STATE OF NORTH CAROLINA
DEPARTMENT OF TRANSPORTATION

August 11, 2004

SUBJECT: **Permit Modification Request for TIP No. R-2809B**, Wake County, NC
DOT Division 5, Federal Aid No. STP-98(1), State Project No. 8.1402501,
USACE Action ID 199601836, and DWQ Project No. 010550, \$475 Debit
Work Order WBS Element 34503.1.1

SHEET 17 OF 26

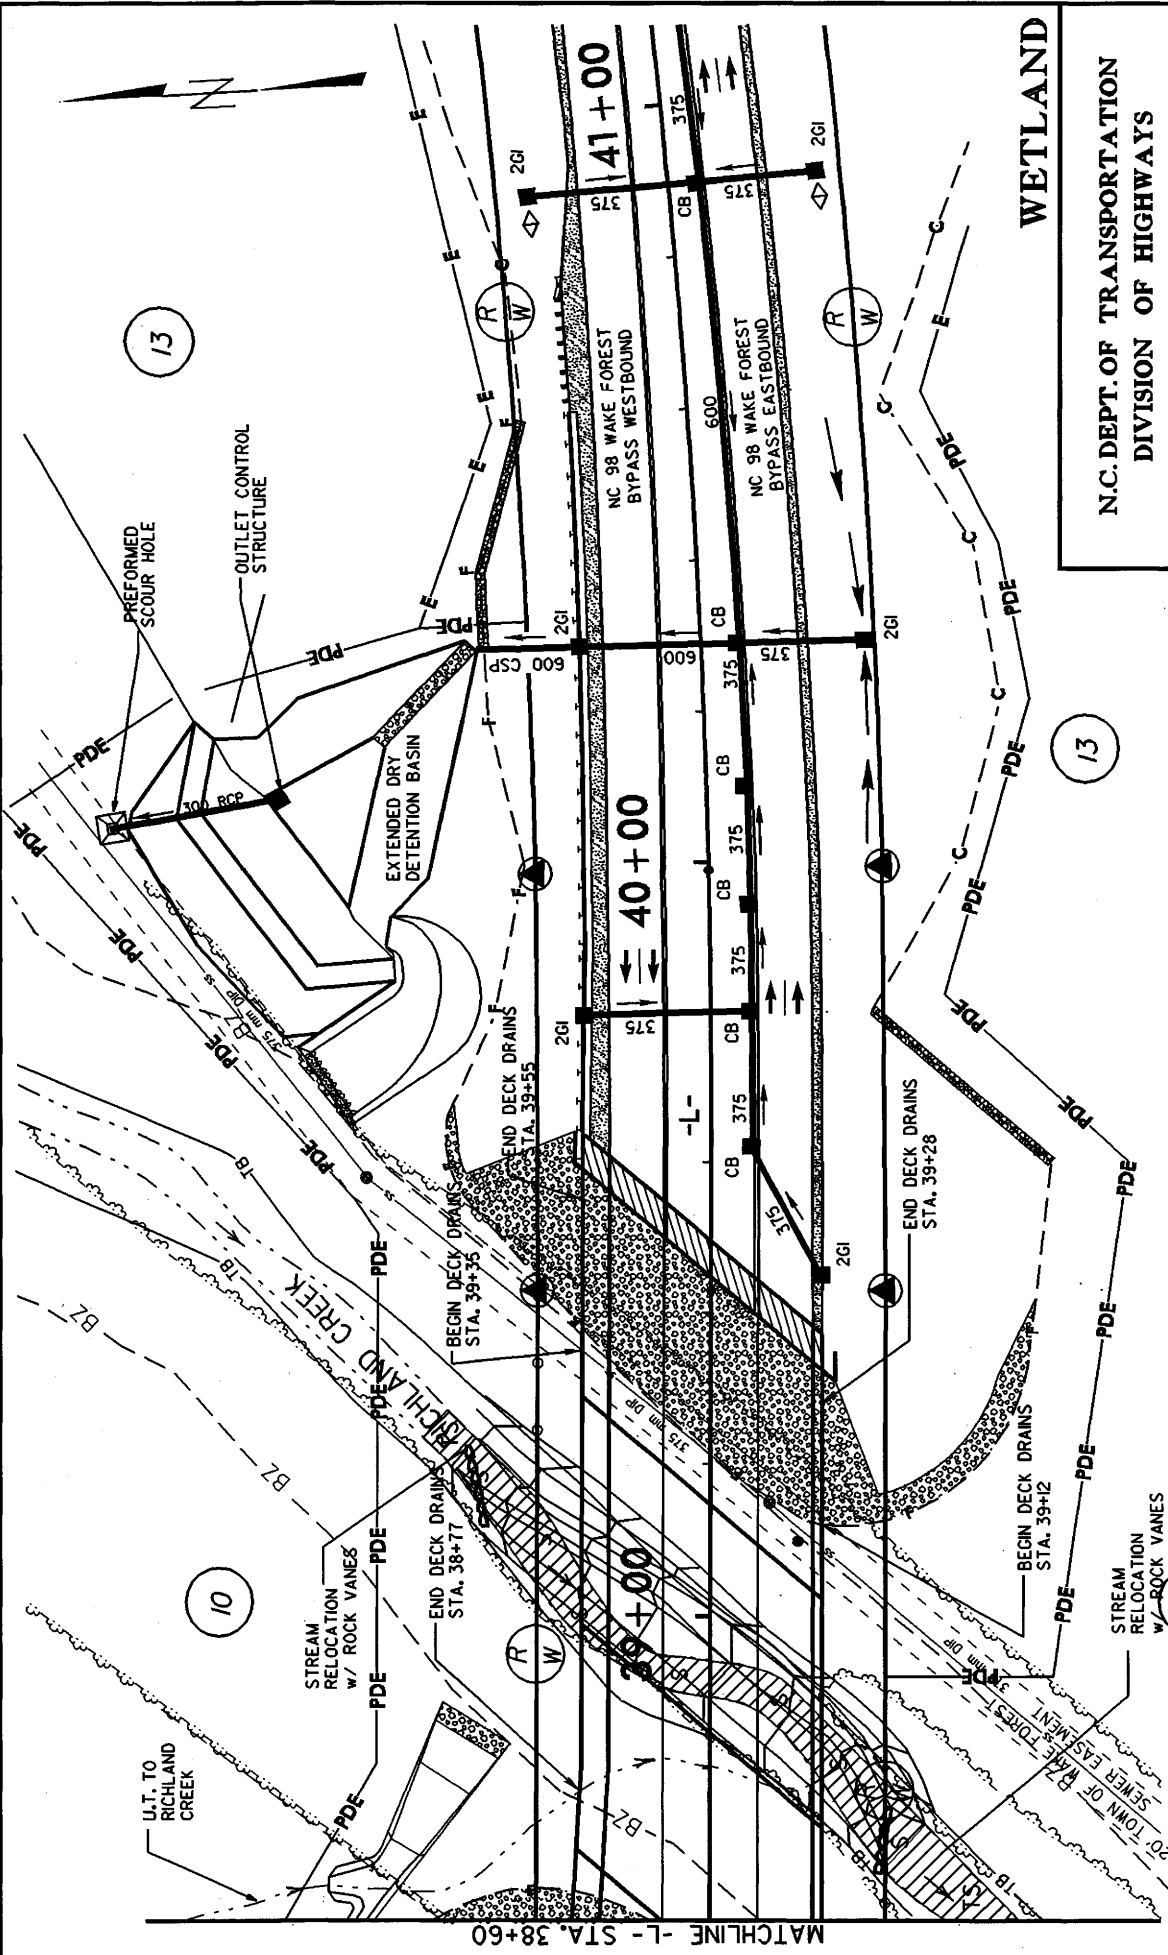
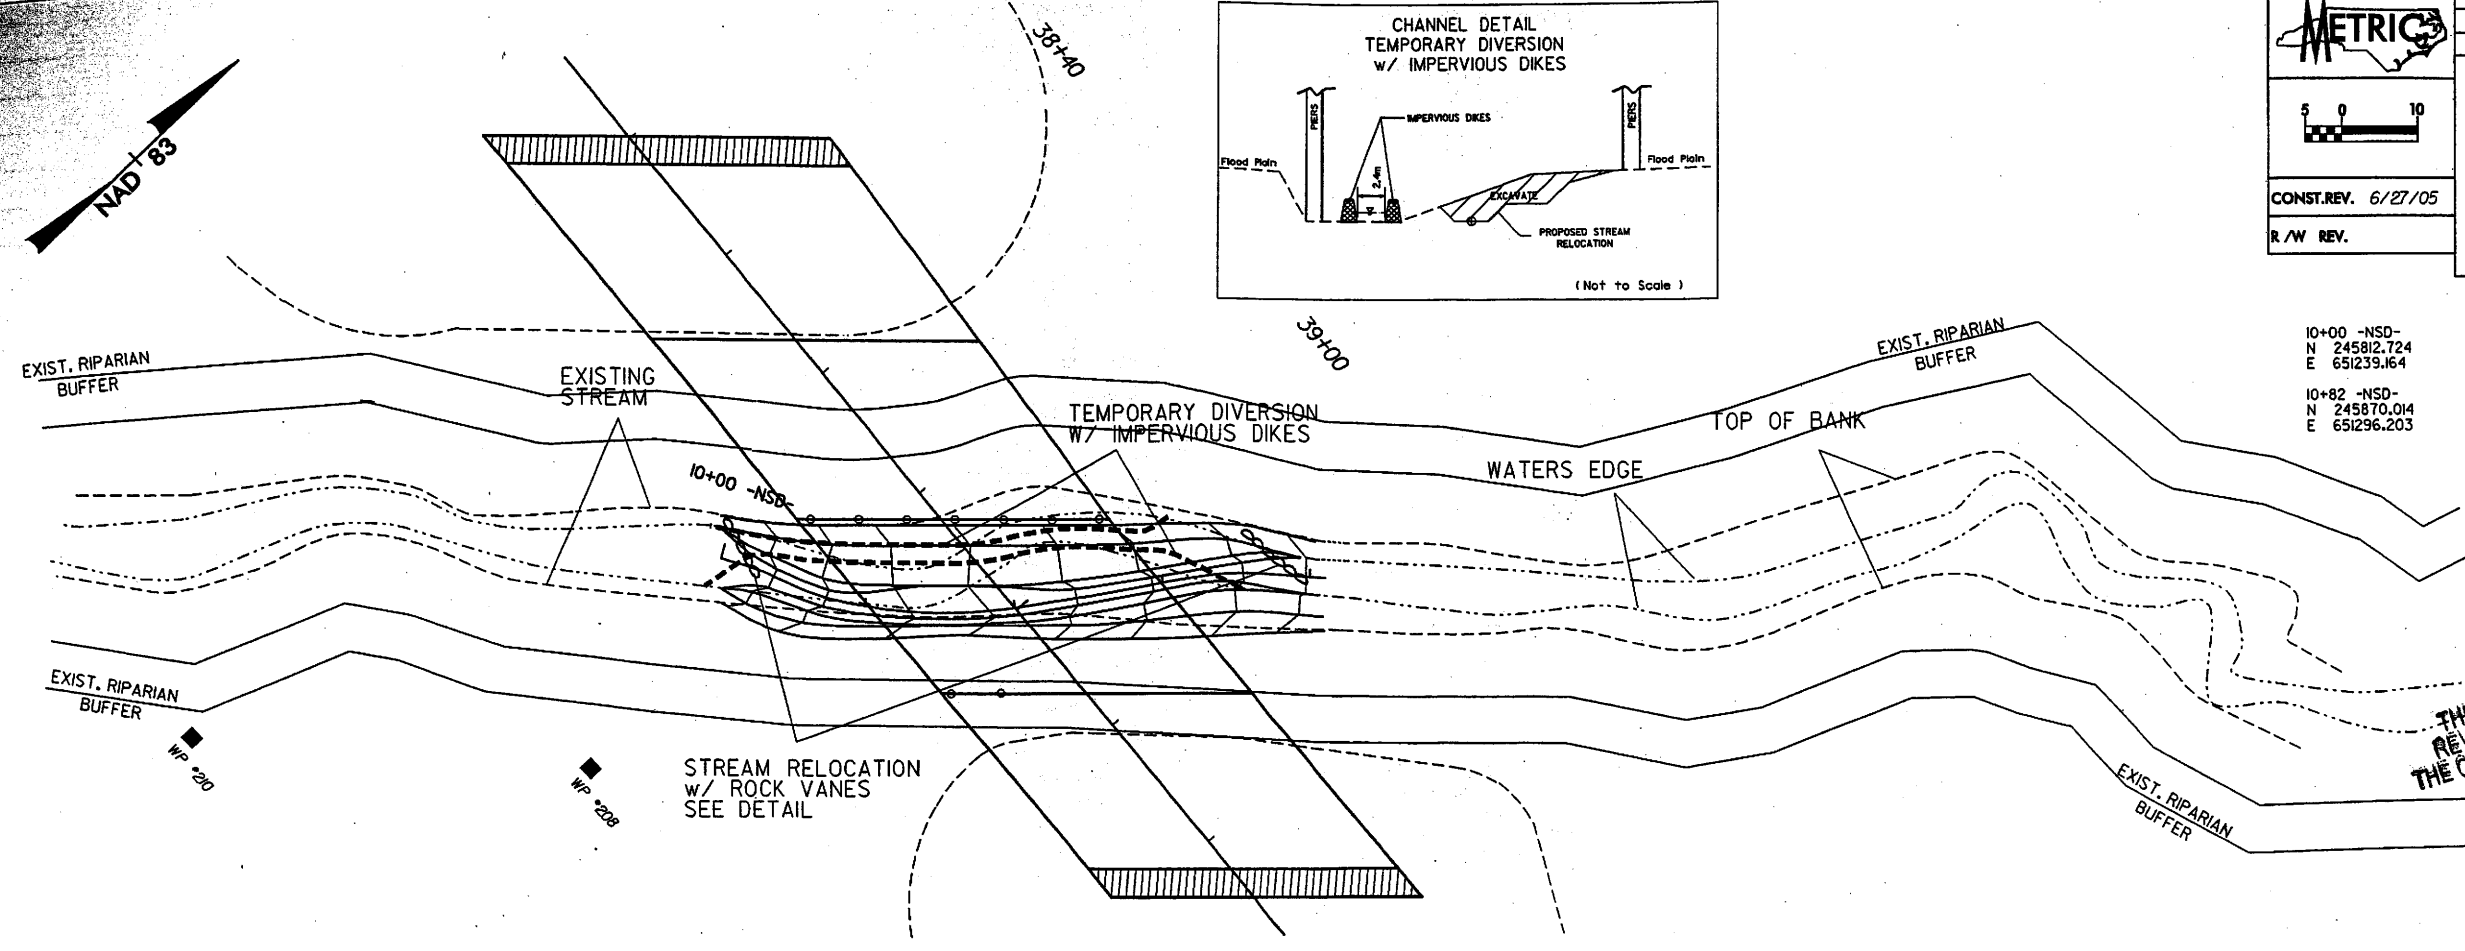
Site 4, Sheets 17 and 18 of 26

Station -L-38+84

The original survey of Richland Creek was inaccurate and did not take into account a bend to the west. The project was originally designed so that all bents would not be placed in Richland Creek. However, due to the inaccuracy of the survey, piers 1 and 2 of the bent 2 would fall in the stream. An onsite field meeting was held on June 17 between NCDOT officials, USACE and NCDWQ. During the meeting it was agreed that the banks of Richland Creek were not stable and that Richland Creek could be relocated using natural stream design. Approximately 351 feet of Richland Creek will be relocated. Due to the limited amount of space between the bents and an existing below ground sewer line the relocation of Richland Creek will require two phases of temporary diversion channels. The sequencing of the stream relocation is as follows:

- Isolate diversion (secondary diversion) with dikes
- Dig diversion (secondary diversion)
- Install dikes in Richland Creek around proposed piers 1 and 2 and take out dikes isolating temporary secondary diversion
- Drill and install piers 1 and 2
- Construct main diversion, establish vegetation and reroute water
- Construct stream relocation, establish vegetation and reroute water

Impact change: increase of 351 ft of permanent Stream Impacts

Increase of 351 ft of Natural Stream Design

Increase of 82 feet of temporary Stream Impacts
